Our Ref: CM/2/21/DOC

Approval of details reserved by condition imposed under CM/21/19/PL relating to conditions 10-schedule of materials & finishes; 11-proposed surface water drainage; 12-discharge of flows to watercourses or for the culverting, diversion, infilling or obstruction of any watercourse on or adjacent to site & 13-maintenance & management of surface water drainage system.

Scyld Horsemere Green Lane Climping BN17 5QZ

Arun District Council have decided to **REFUSE details reserved by condition for the following reasons:**

DRAINAGE GA

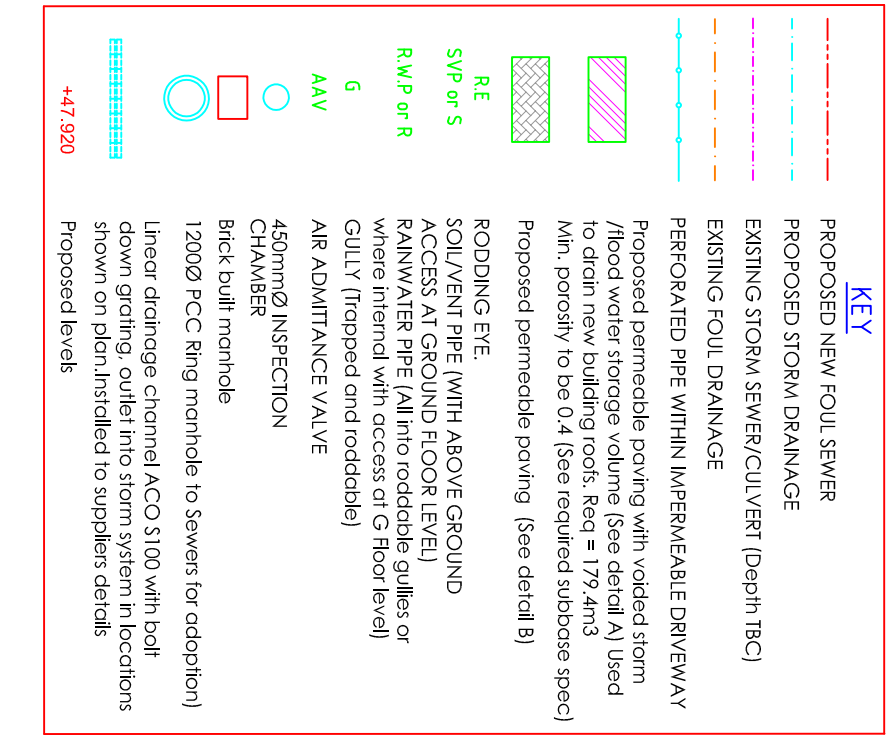
- The calculations submitted use FSR rainfall and a cv of 0.75, please use Cv=1 or the latest FEH rainfall.
- The invert level, and flow restriction of the hydrobrake are inconsistent between calculations and layouts. Please update to ensure consistency and include hydrobrake unit reference on surface water drainage layout and construction details.

- Modelled slope of permeable paving should be accurate.
- Finish and formation levels of permeable paving require detailing.
- All pipe diameters and falls should be detailed on plan.

- A minimum of 300mm sump depth should be provided upstream of all connections into the permeable paving.
- Where connections are being made to pipelines rather than direct to manholes add note that all connections to be made using oblique 45 degree junctions.

- Bed level of ditch upstream and downstream of proposed point of discharge, as well as at the point of discharge should be indicated.
- Invert level of outfall to ditch should be clearly indicated and update to the position so this is accurate.

- No connections are shown to/ from the permeable car park areas. Given the depth of groundwater these structures should be lined and have a positive means of drainage. Please ensure these areas are included within calculations and link to the road drainage.

STORM WATER DISCHARGE INTO PERMEABLE
PAVING SYSTEM DETAIL

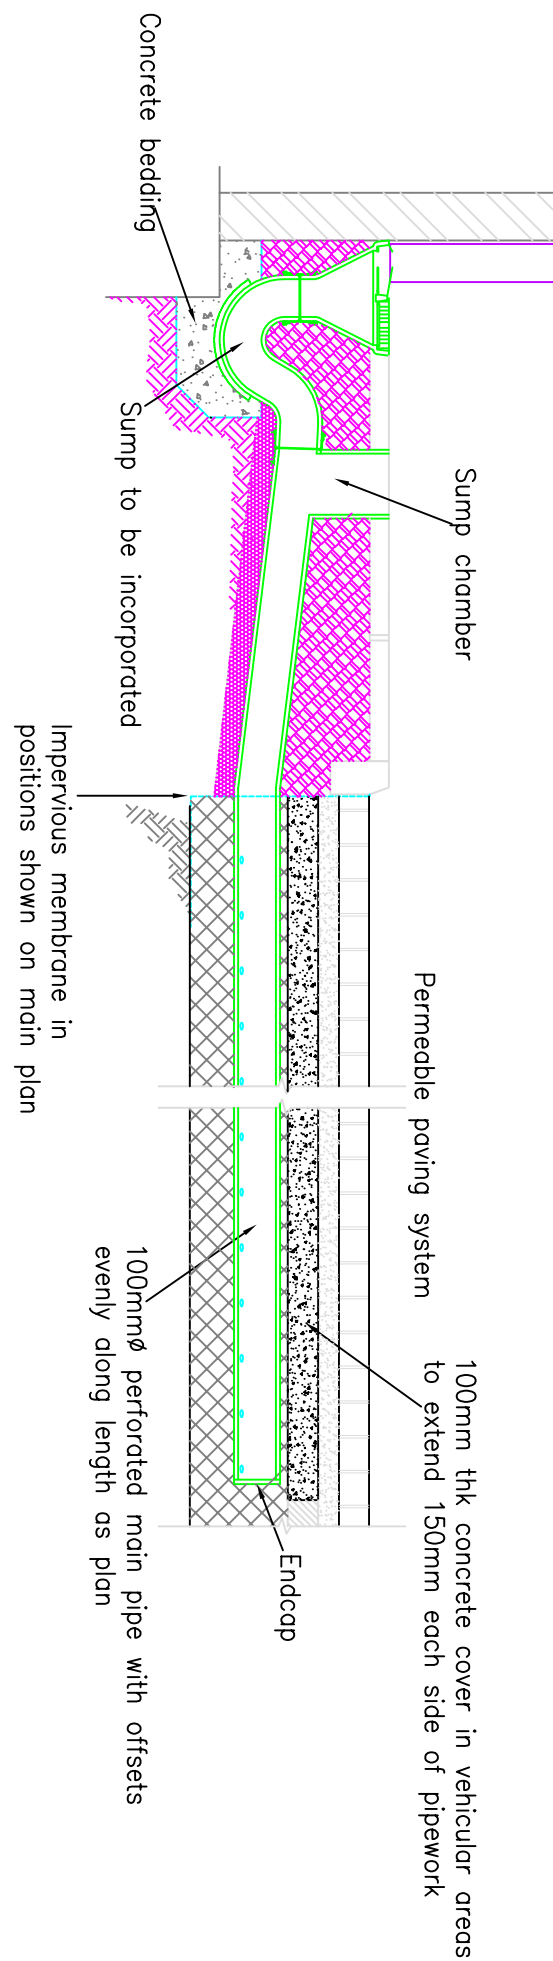
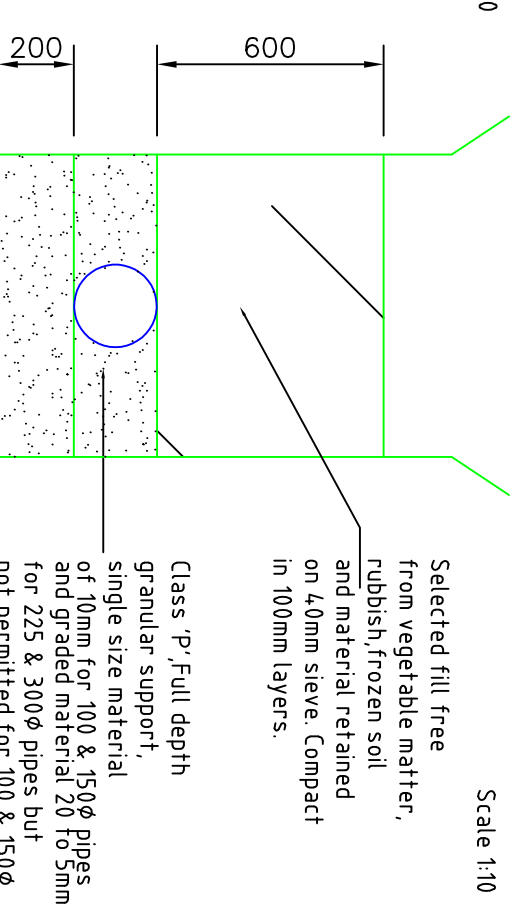
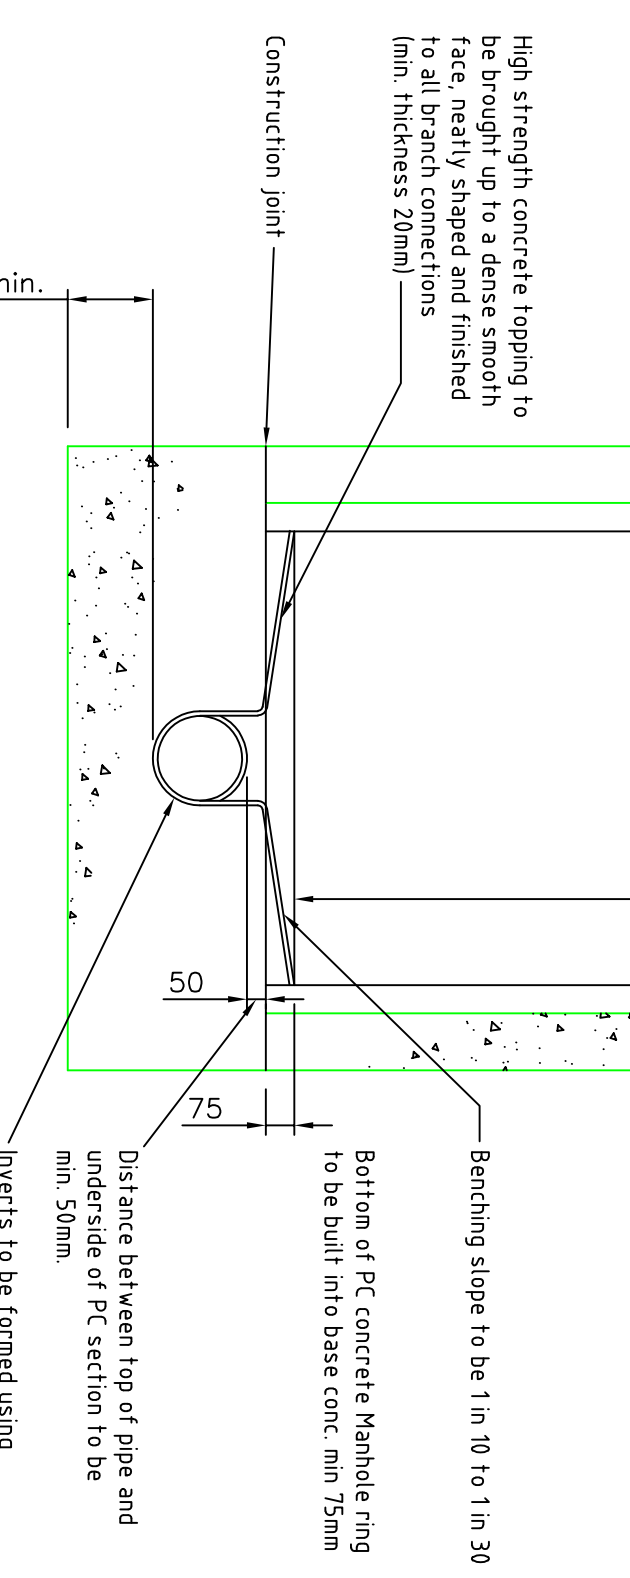
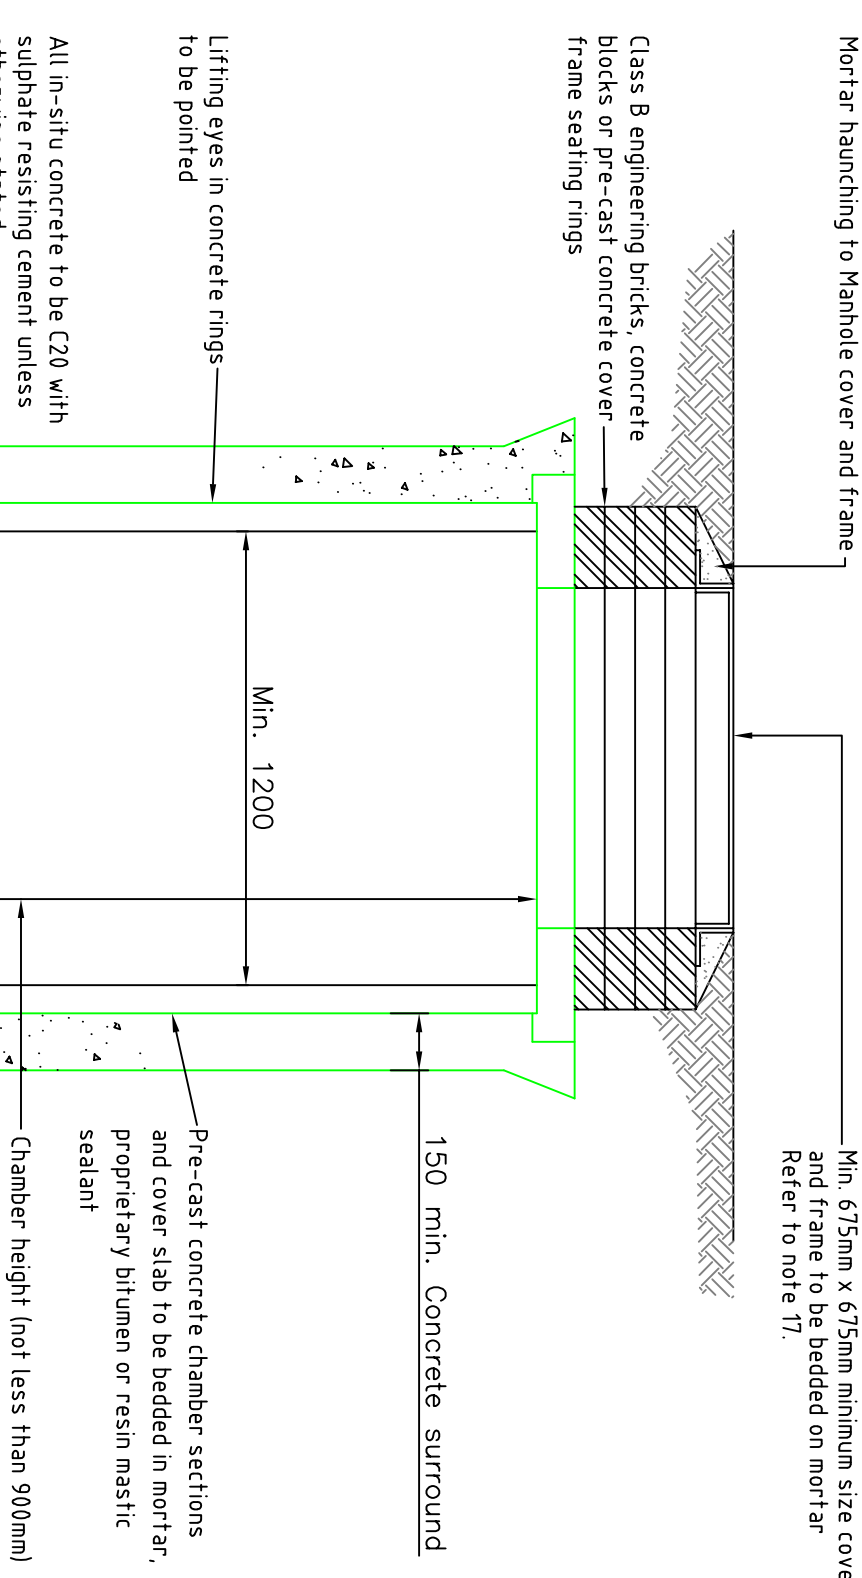
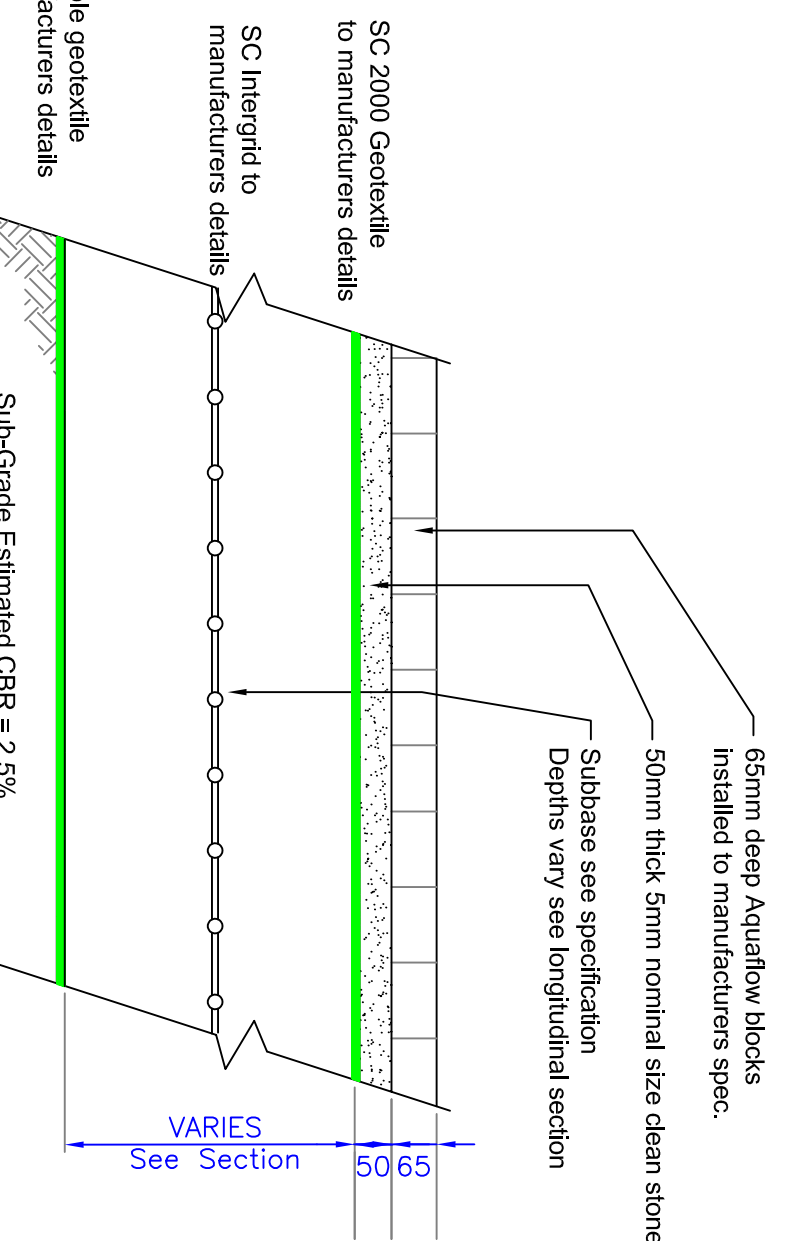
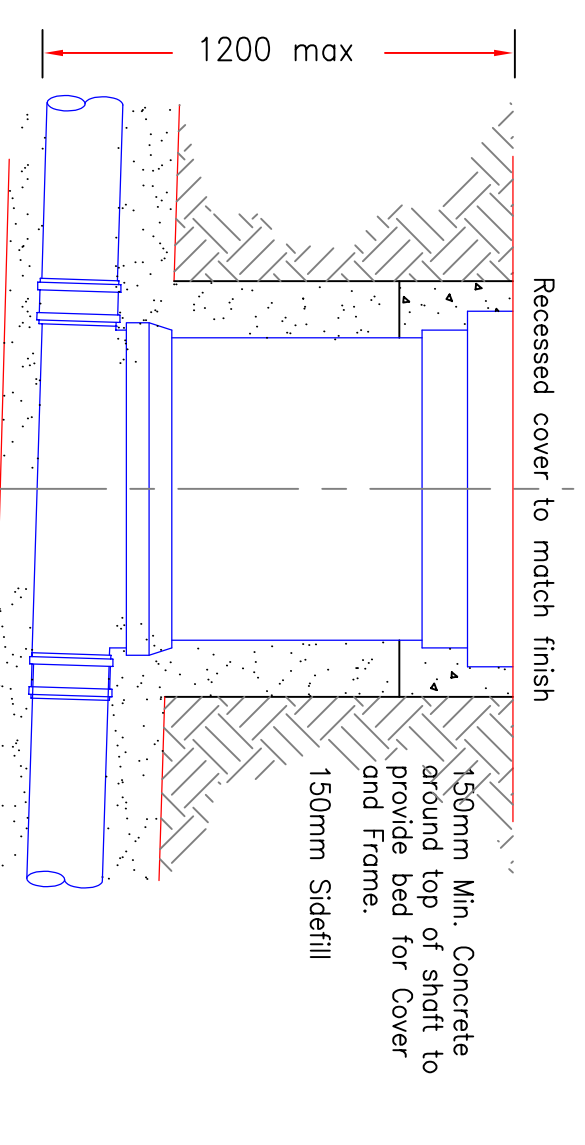
- Construction detail drawings of : hydrobrake (site specific); drainage channels, catchpits, and proposed headwall should be provided.
- The permeable paving details must show an impermeable membrane around the side and base.

- The permeable paving details must indicate minimum depth of sub-base and sub-base material.
- It is noted that it is proposed to have a 100mm thick concrete cover slab over the top of the perforated main pipe, with 150mm each side of pipe work. This would have to be constructed very carefully so as not to cause concrete ingress into the perforated pipe, and it will also result in a strip of road being impermeable. Has the use of diffuser units been considered instead with a small fall in formation over the site? The outlet diffuser unit would have to be at the base of the sub-base. As should the pipe at the downstream end if this is to remain.
